From: Simon Davis
Sent: 28 April 2021 17:07
To: Julia Davies [REDACTED]
Subject: RE: North Barn, Flansham (Y/22/21/PL)

From: Julia Davies [REDACTED]
Sent: 28 April 2021 16:28
To: Simon Davis <Simon.Davis@arun.gov.uk>
Subject: North Barn, Flansham (Y/22/21/PL)

Drawing P02 January 2021 Scale 1:20 & 1:100 @ A3
Proposed Drawing - Site Plan & Fence Details

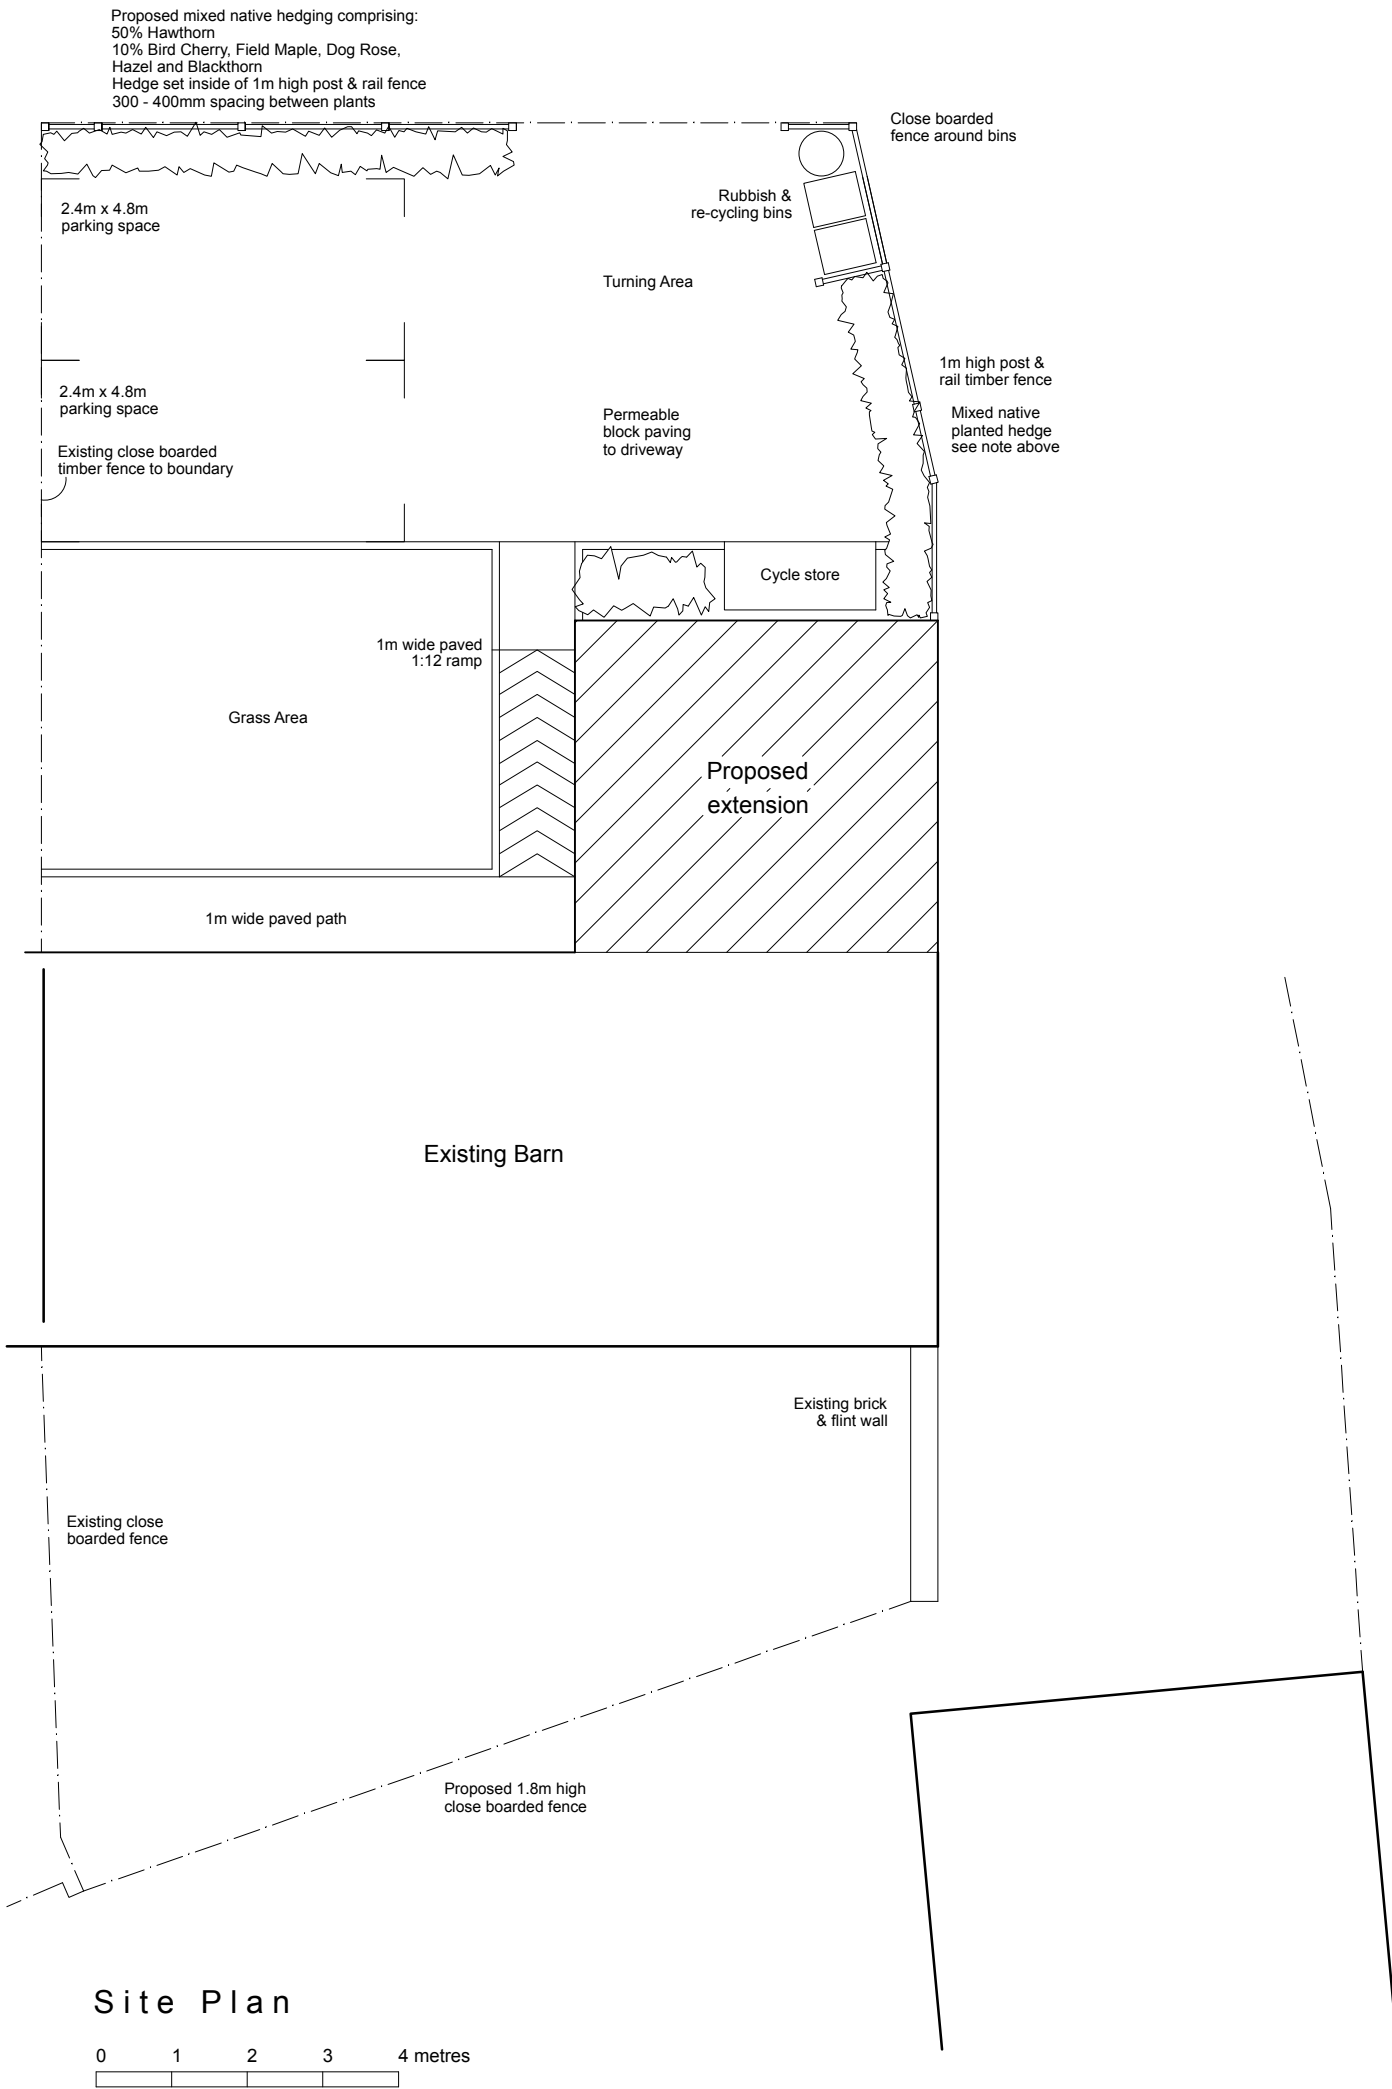
6. Landscaping scheme was included as part of the planning application, the information provided was in line with that required in the condition on the previous consent for the site. Could you please therefore clarify why this condition has been imposed?

As per the request our Landscape Officer (available on our website) which stated that the scheme is acceptable but that details of the quantities of each species need to be specified and added to the drawing for clarity.
